TERRA ASSOCIATES, Inc.

October 10, 2023
Project No. T-8718

Subject: Response to City of Mercer Island Comments
3036 – 67th Avenue SE
Mercer Island, Washington

- References:
1. Geotechnical Report, 3036 – 67th Avenue SE, Mercer Island, Washington, Project No. T-8718, prepared by Terra Associates, Inc., dated August 22, 2022, 4th revision October 10, 2023
 3. Geotechnical Peer Review Comments, prepared by City of Mercer Island, dated September 2023

TEMPORARY GRADING PLAN
3036 67TH AVENUE SE
SITE PLAN
PARCEL 2174501025
CITY OF MERCER ISLAND WASHINGTON

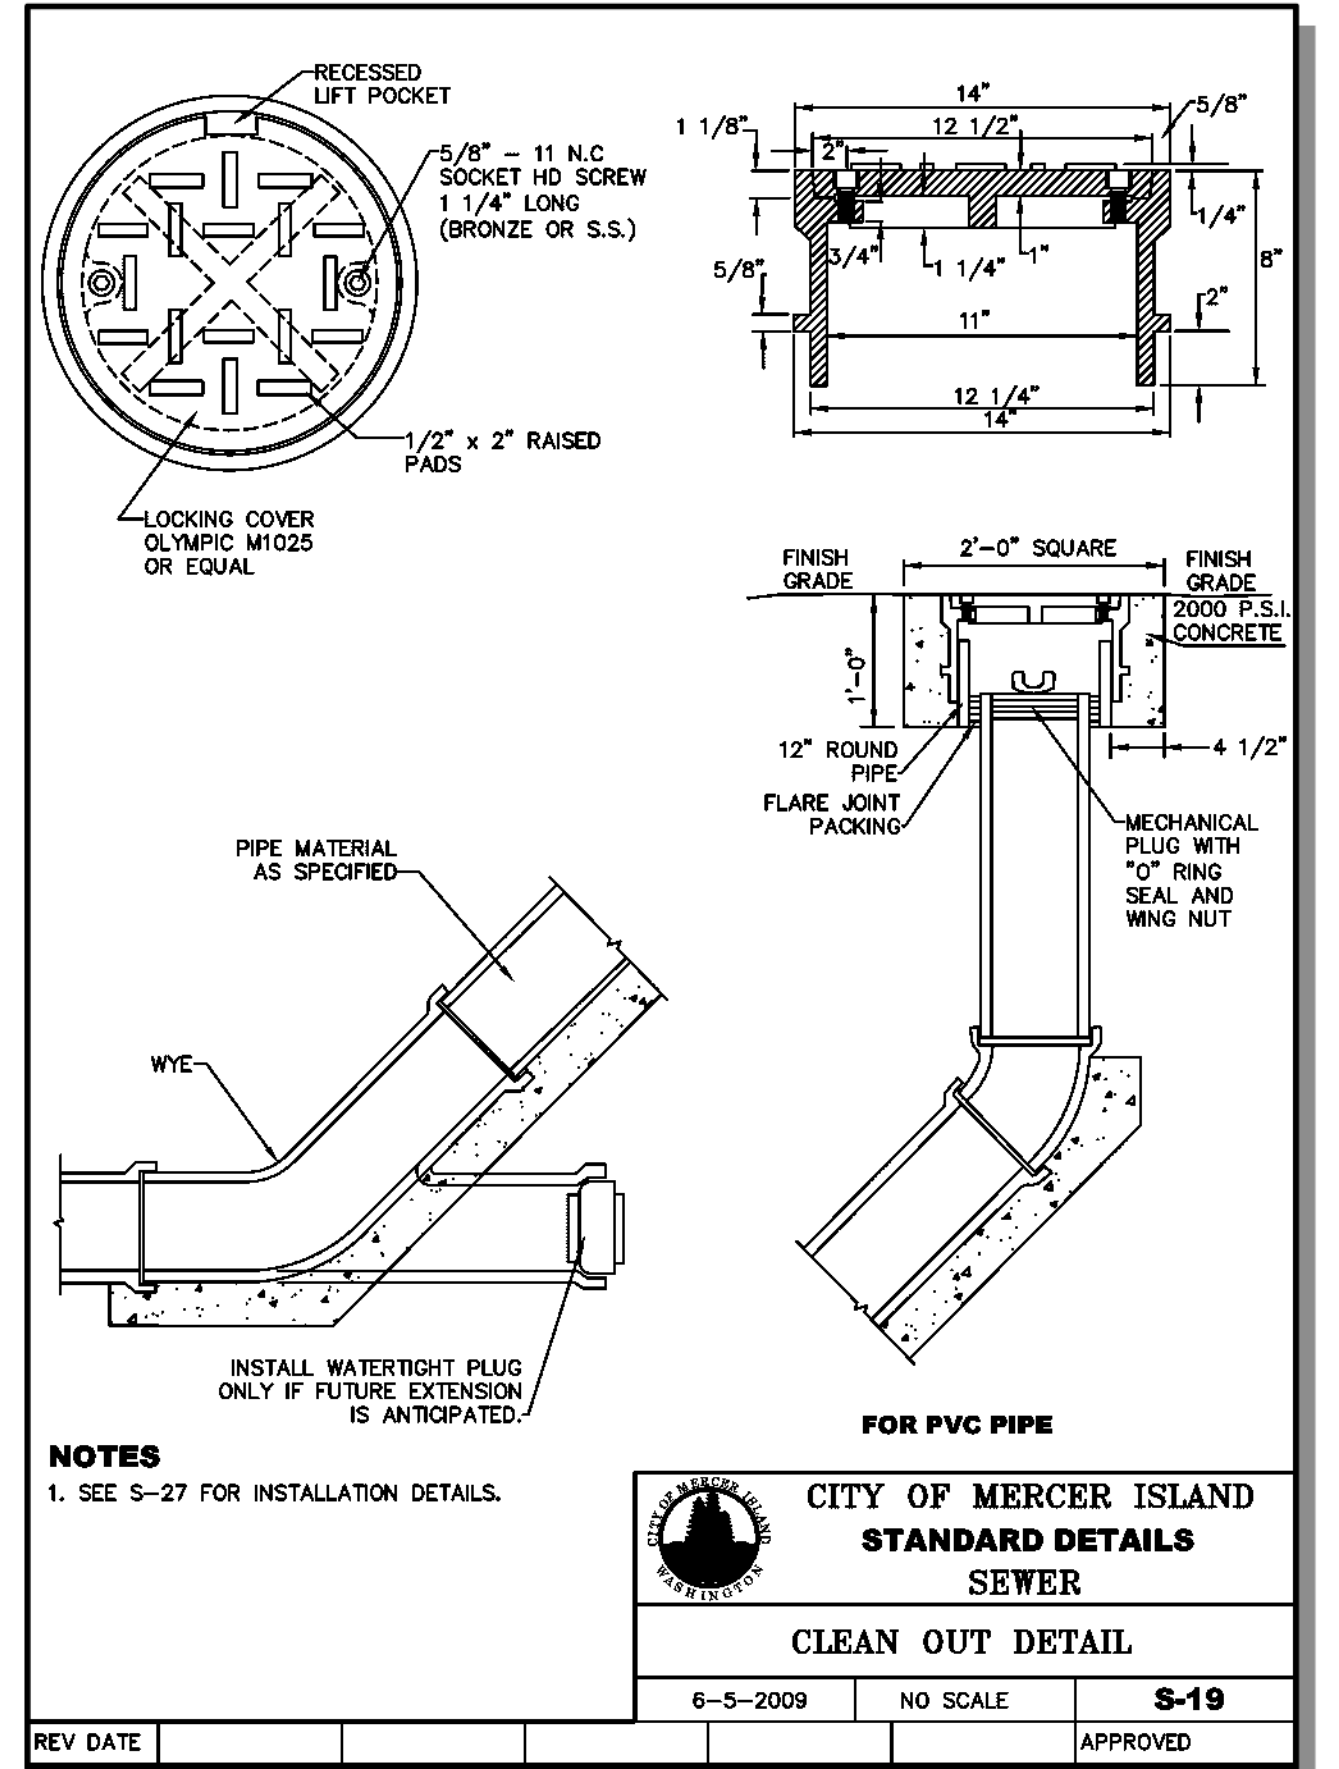
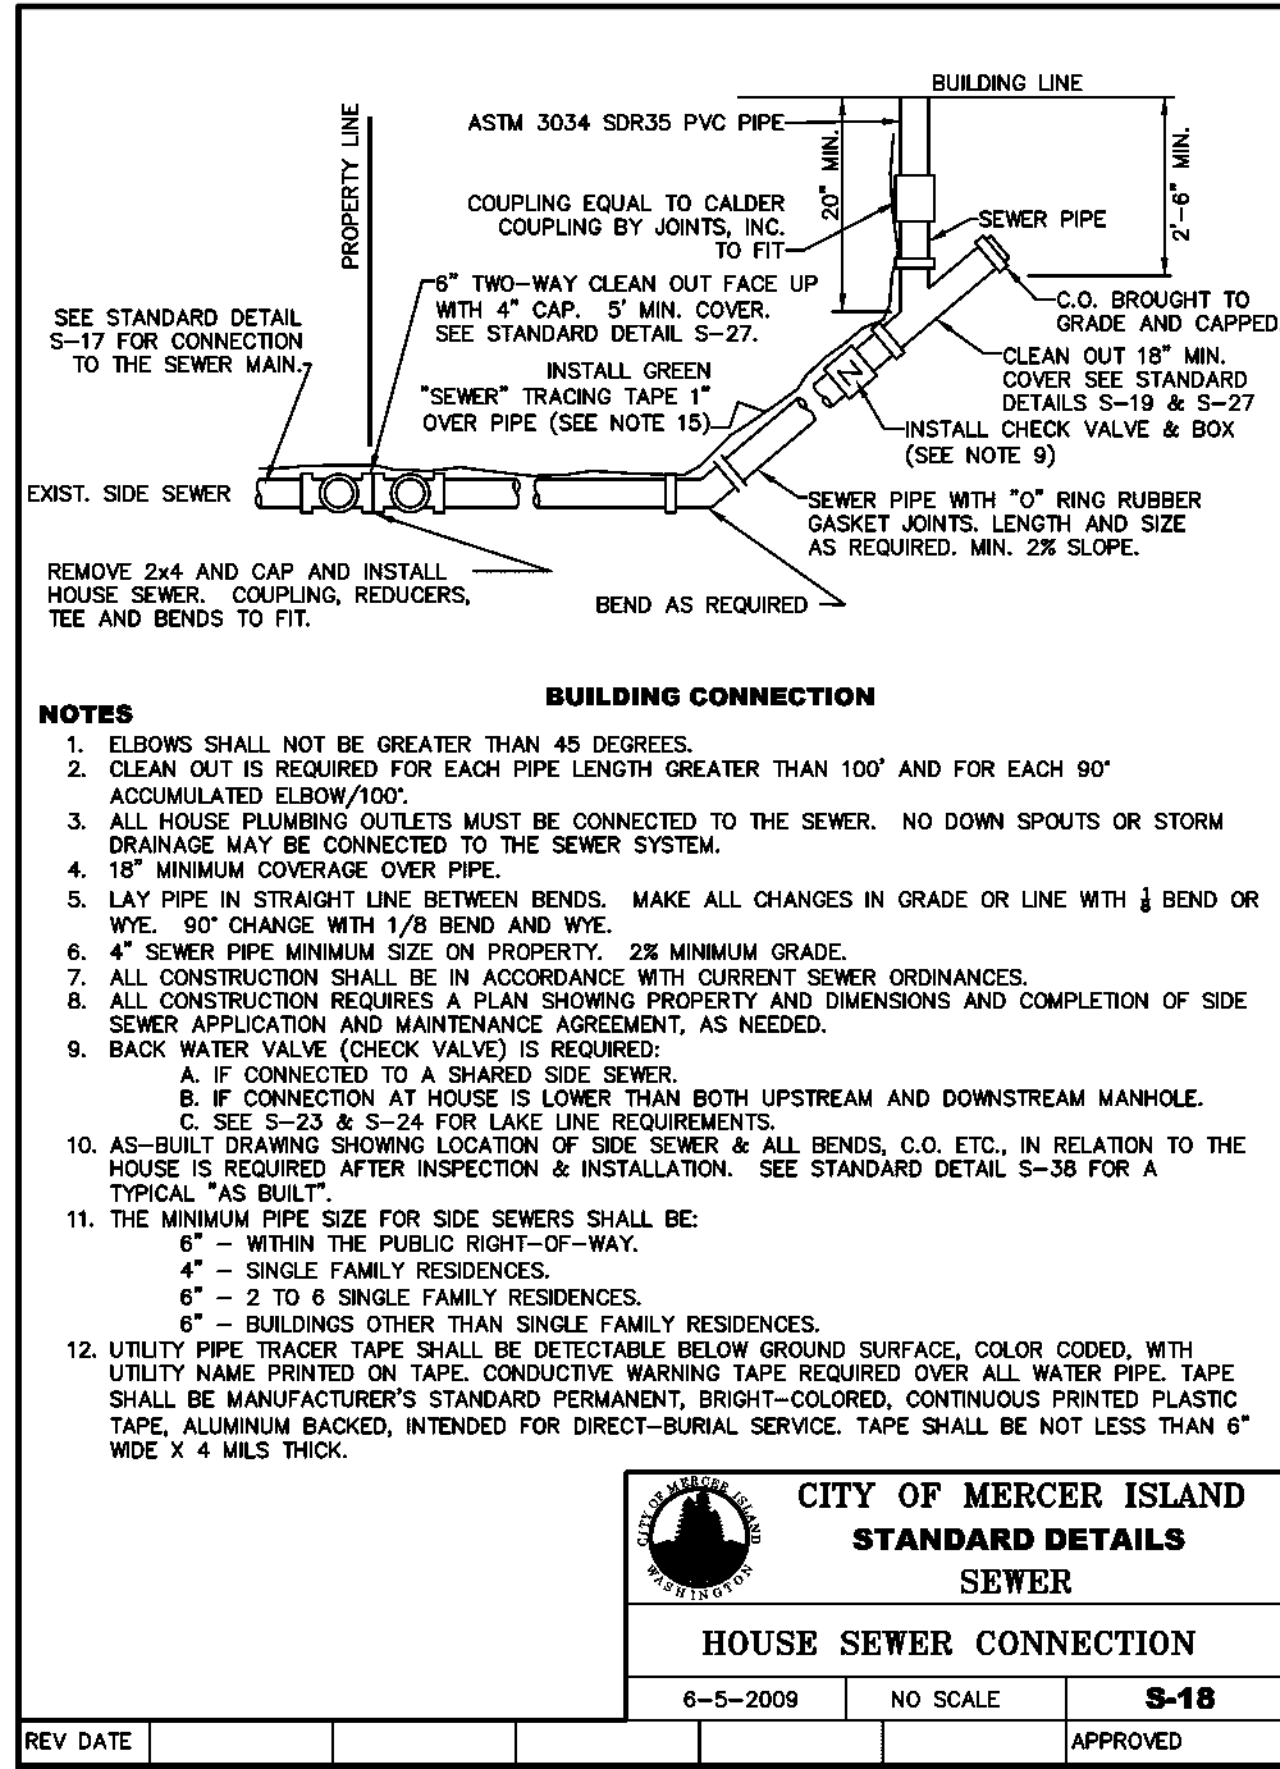
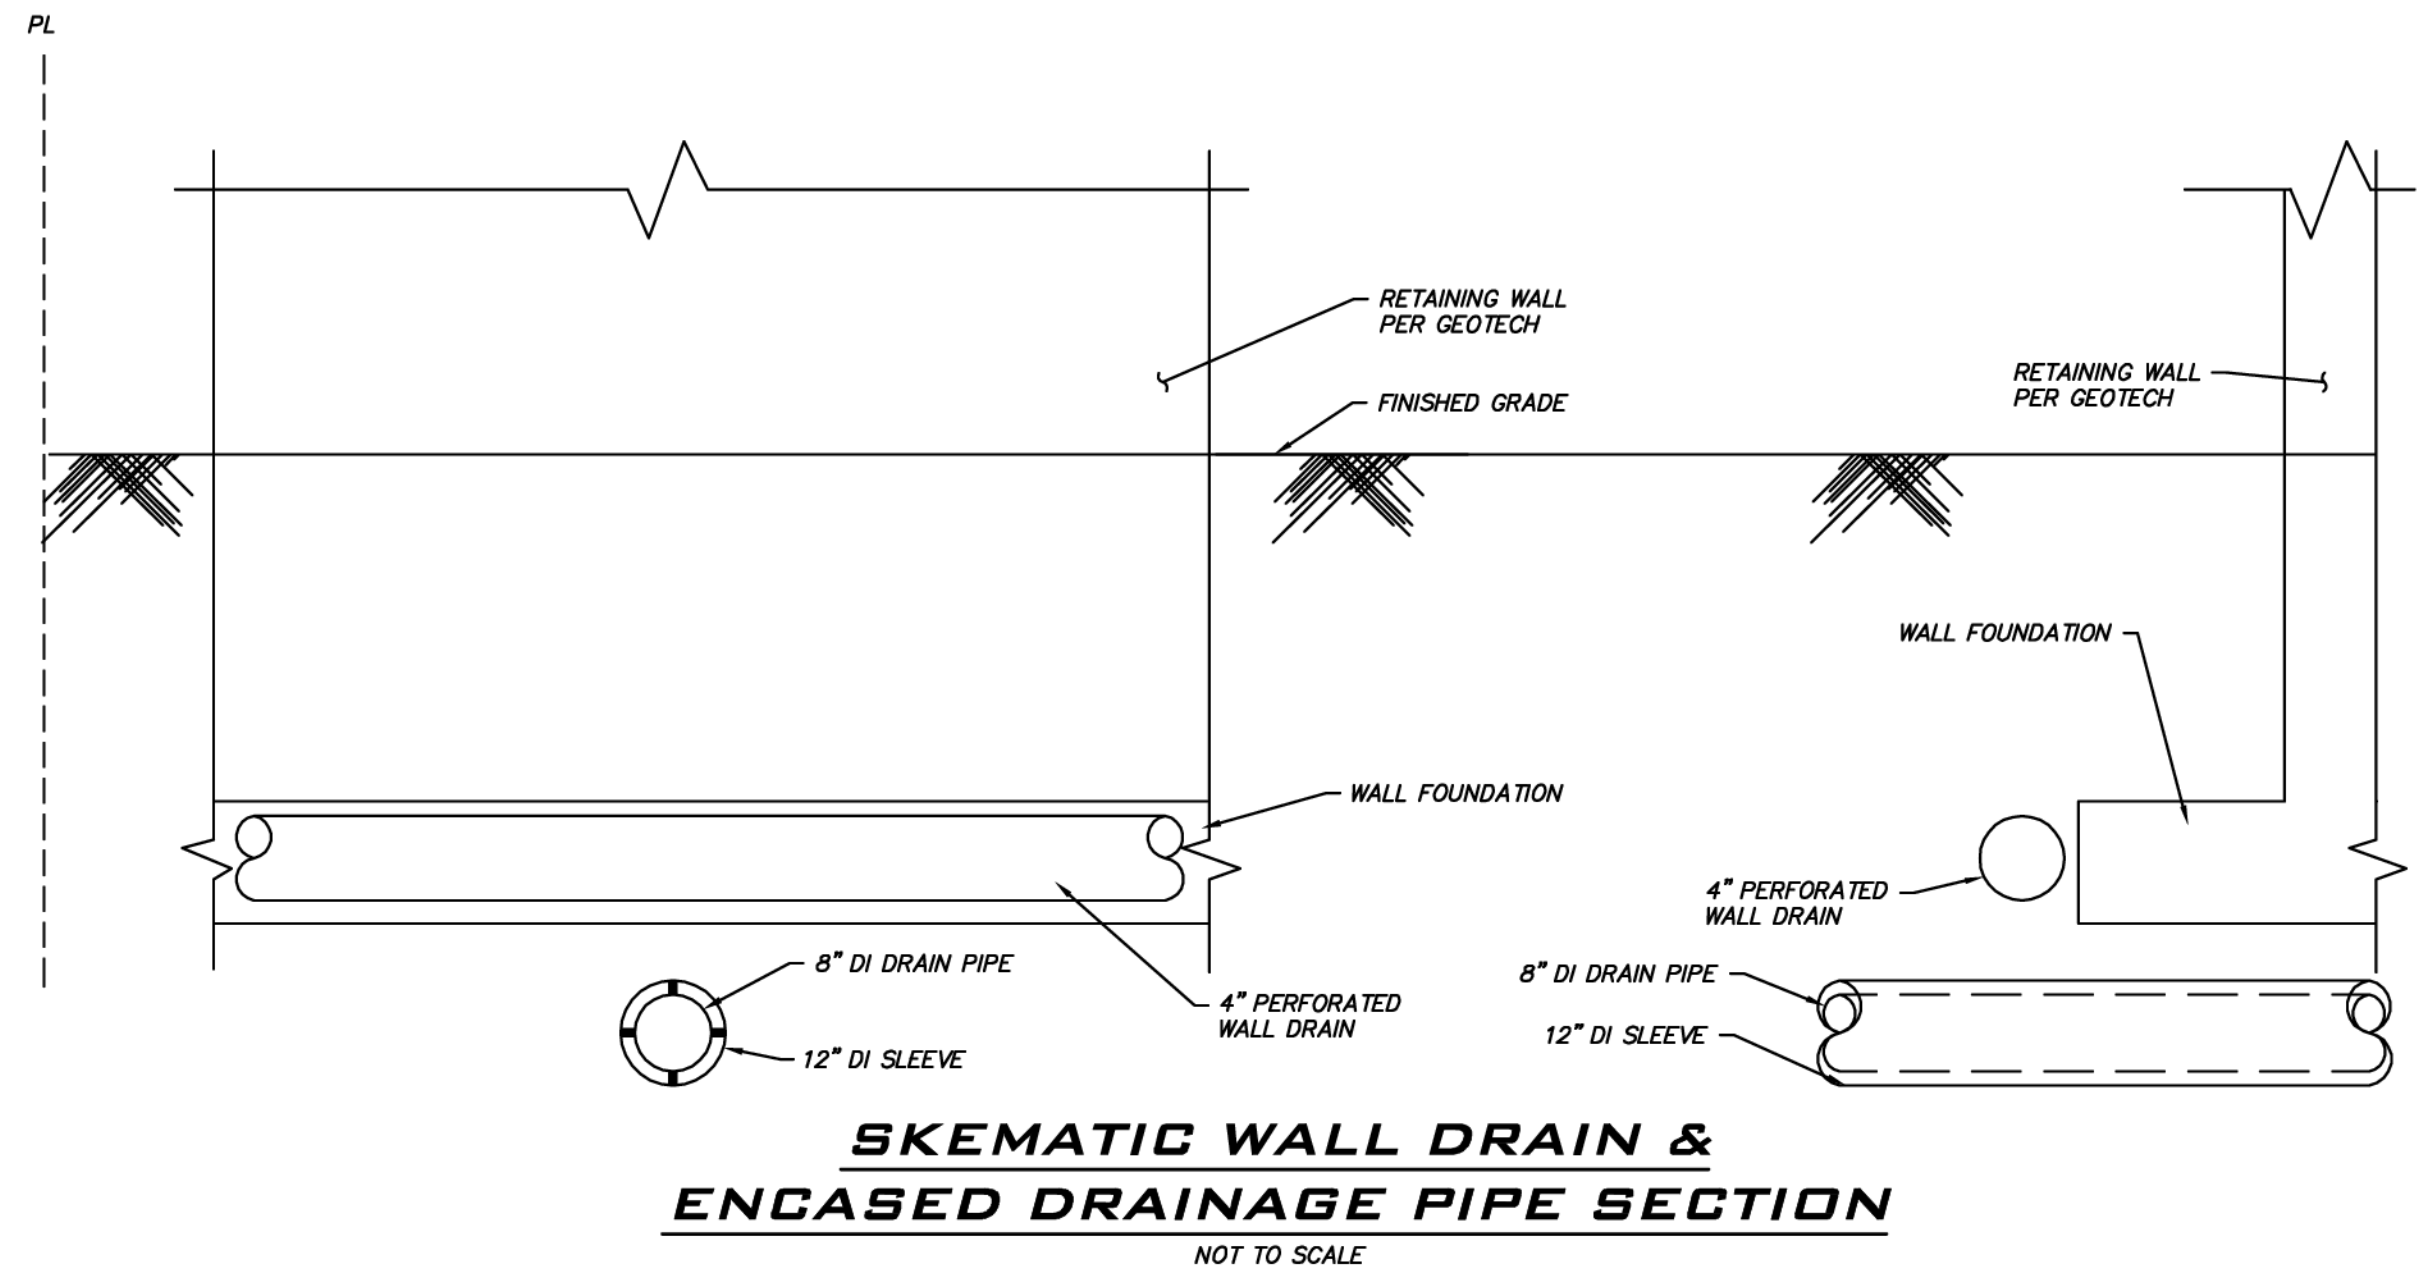
This comment was previously on the cover sheet of the SUB2 planset. It was copied here since it also pertains to the temporary excavation limits and grading shown on this plan sheet. No revisions addressing this comment were noted on this plan sheet.

Please coordinate with geotechnical engineer and review extent of proposed temporary excavations required along all property lines, easements and trees given the anticipated overexcavations below foundations.

If shoring is required to avoid encroaching on these areas (adjacent properties, easement, protected trees, etc.), please provide shoring recommendations, wall design details, calculations, etc. for review.

With no over excavation needed, there is sufficient space to complete the temporary excavation for the building.
